City of Albuquerque

**Re: Eagle Springs Subdivision – Signal Storm Drain Installation
Engineer's Stamp dated 2-19-02, (C19/D26)**

Based on your information contained in your submittal dated 2-19-02, the above referenced plan is approved for Work Order revision with the following changes that should be incorporated on your plan:

TITLE:
EAGLE SPRINGS SUBDIVISION
PAVING PLAN AND PROFILE
EAGLE SPRINGS DRIVE STA 10+00 TO 22+66.75

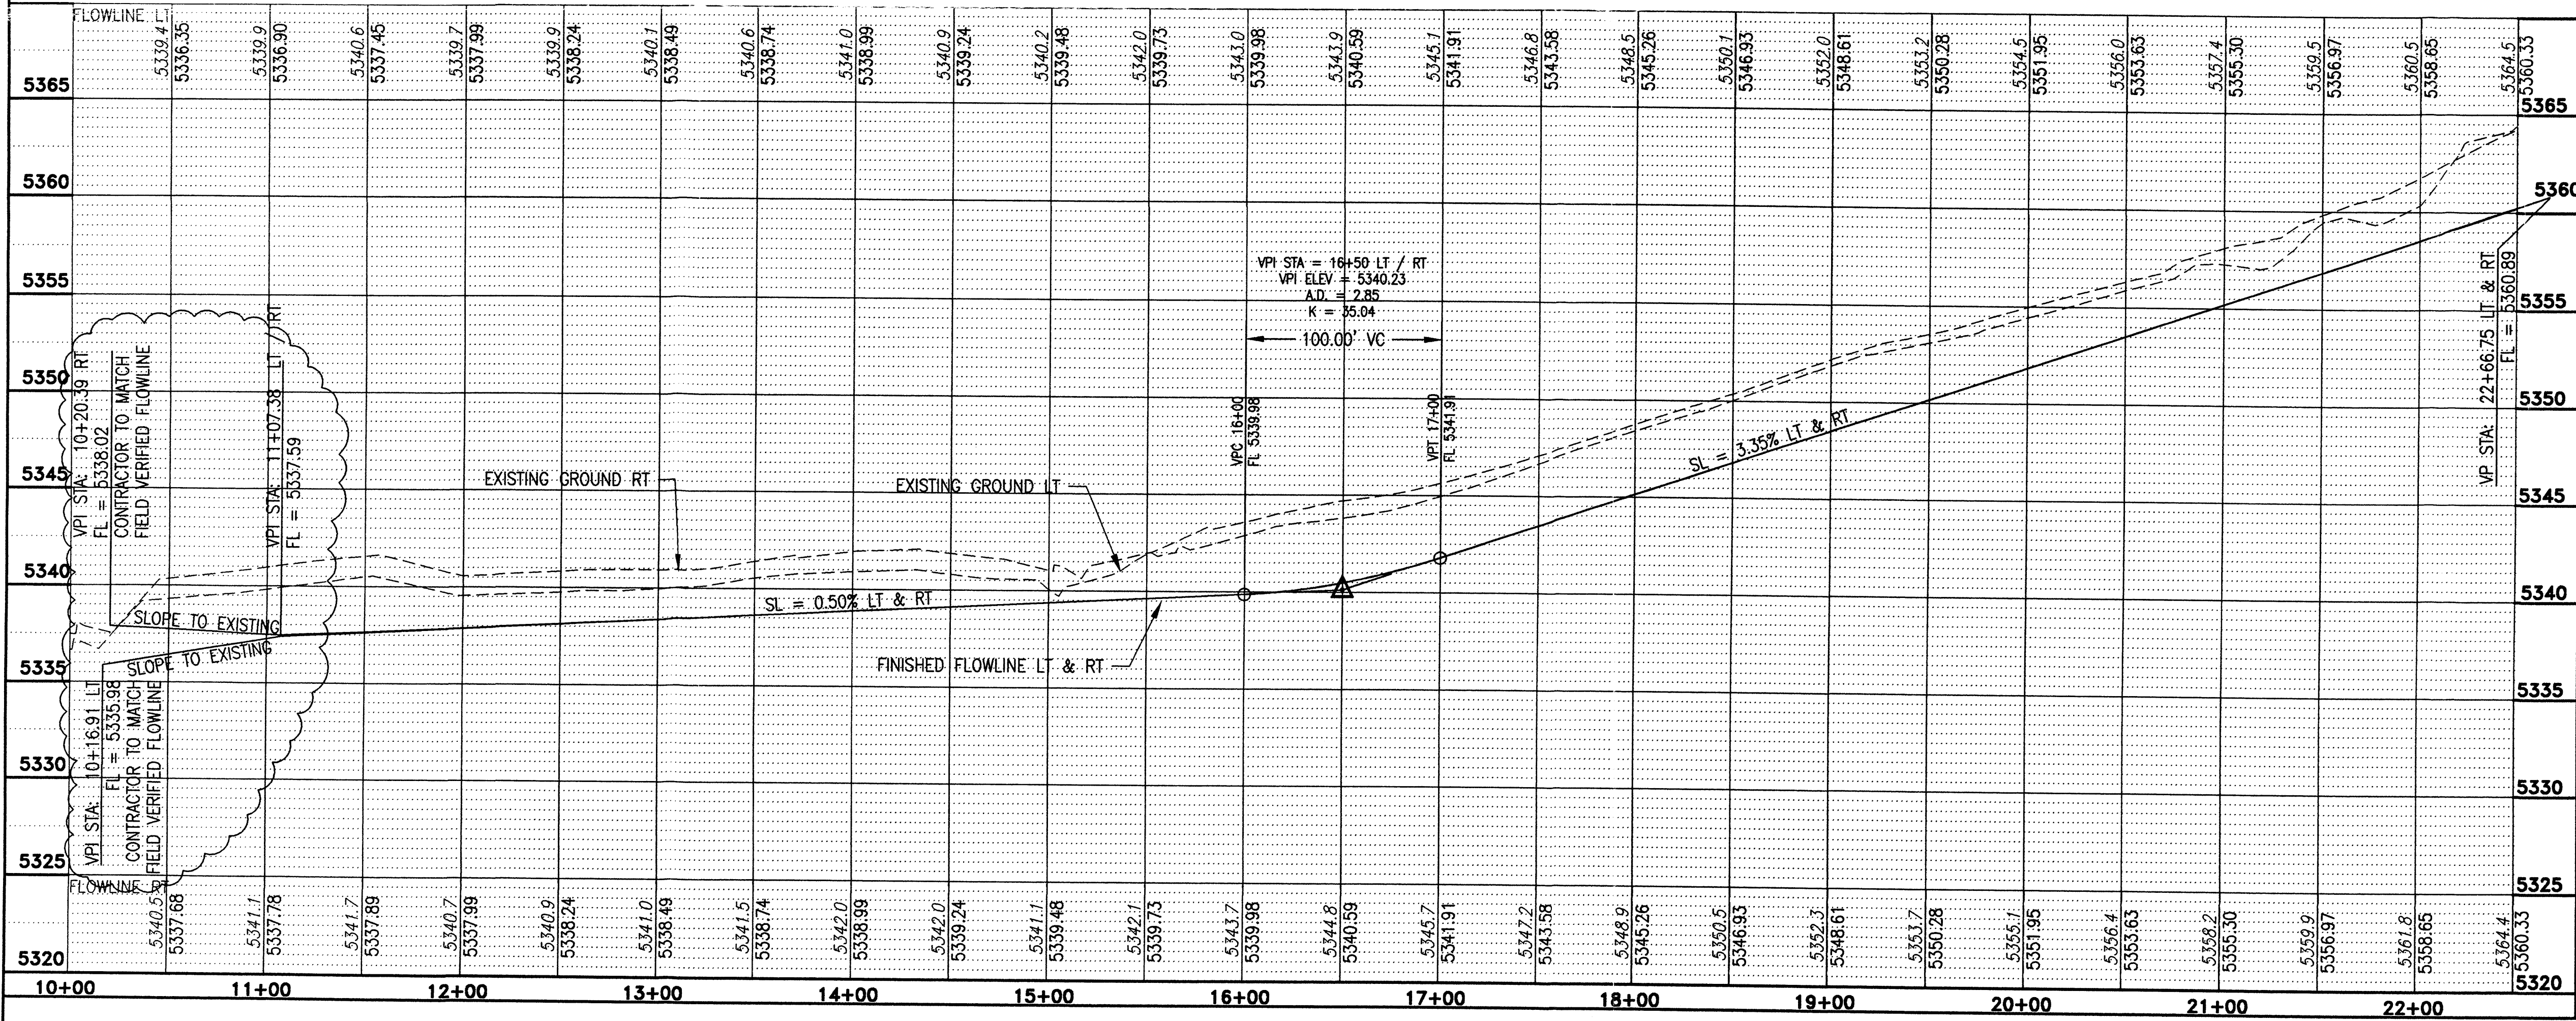
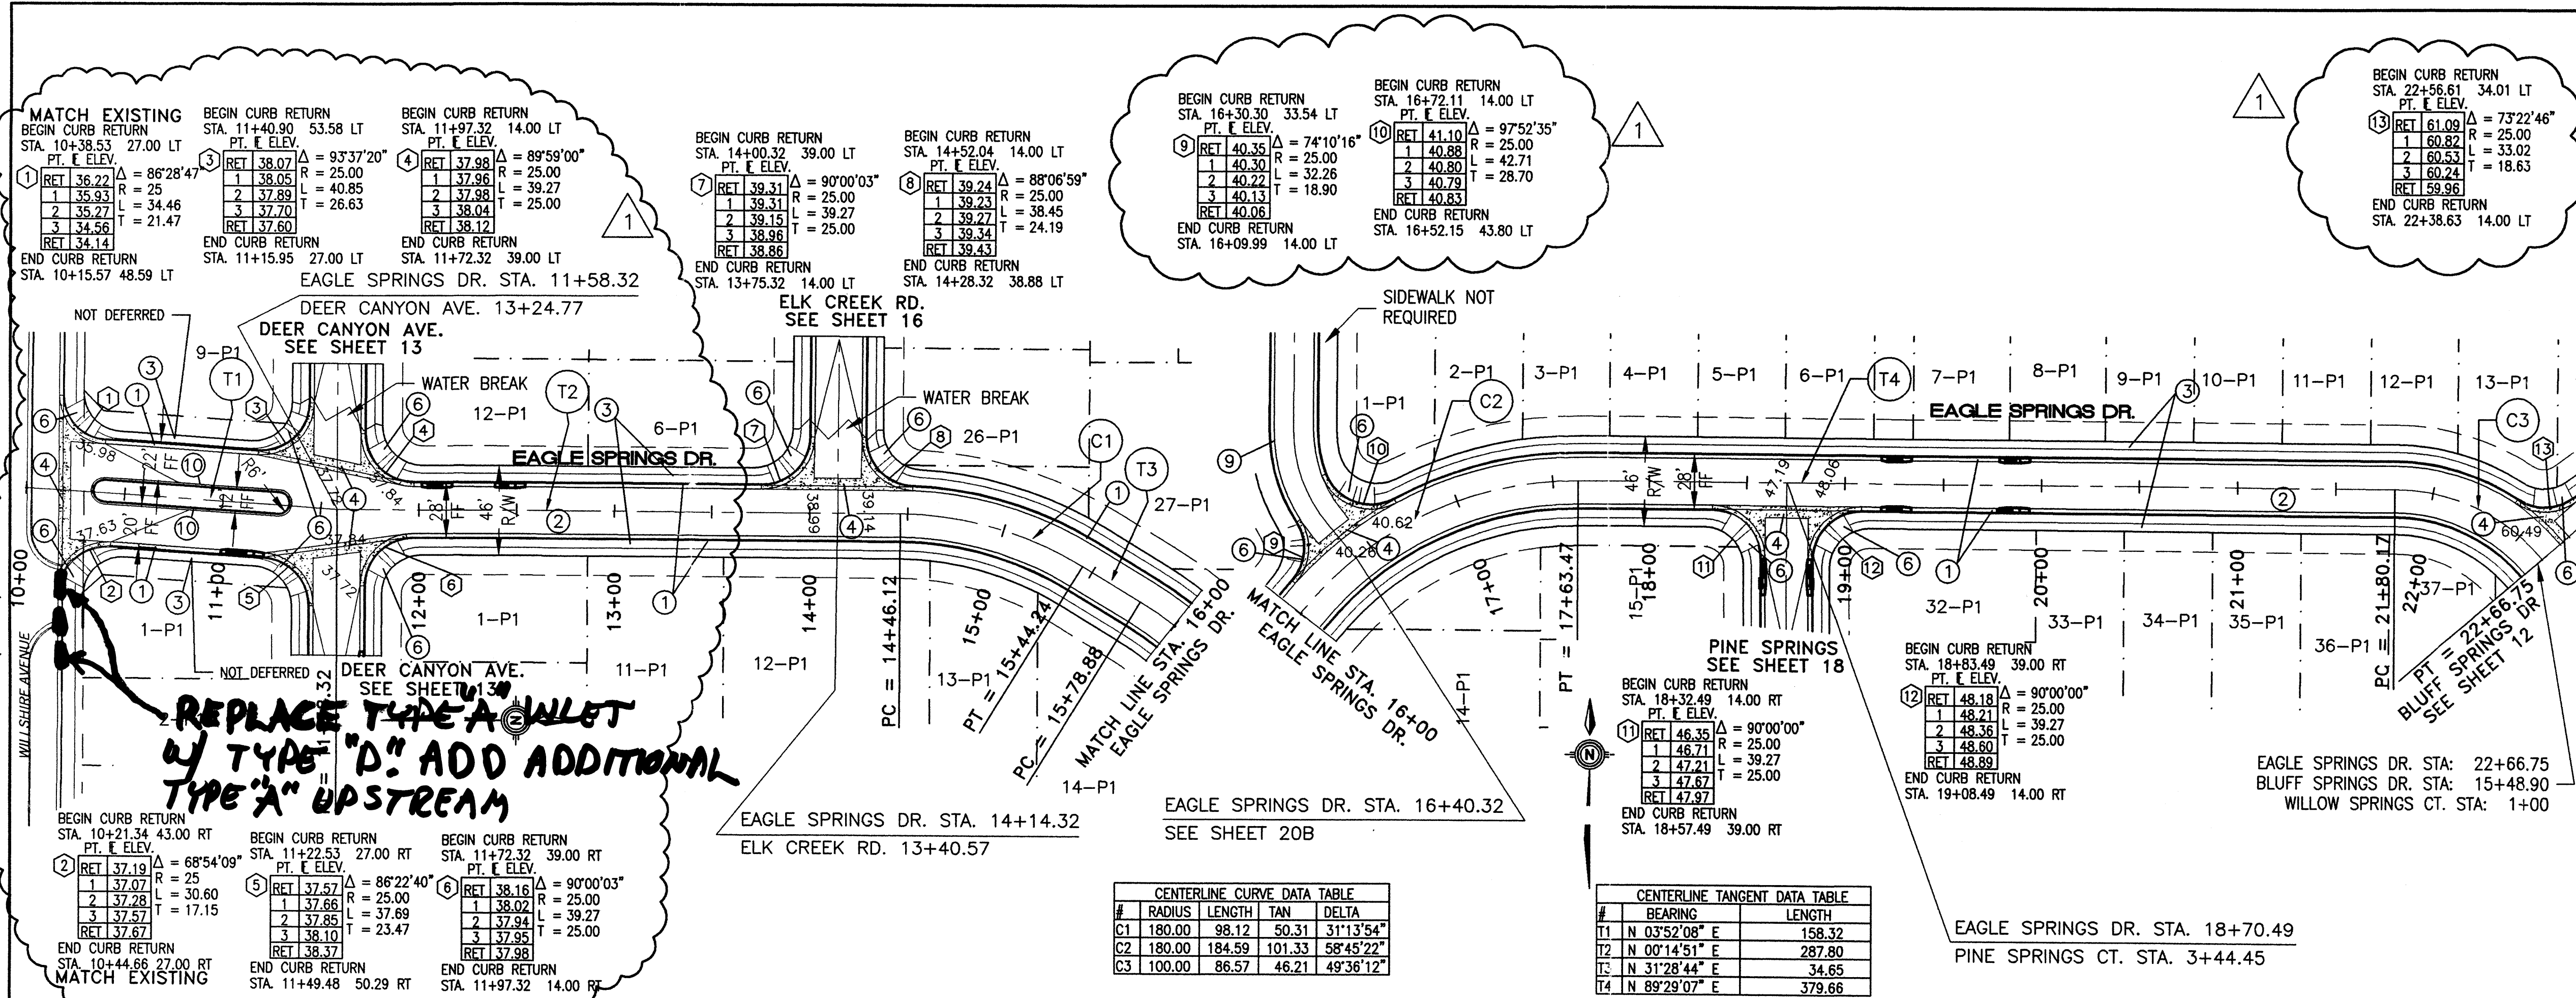
- Please add a manhole and stubs for future inlets and the end of your proposed pipe. Place manhole just far enough upstream that either alternative location you propose will work.
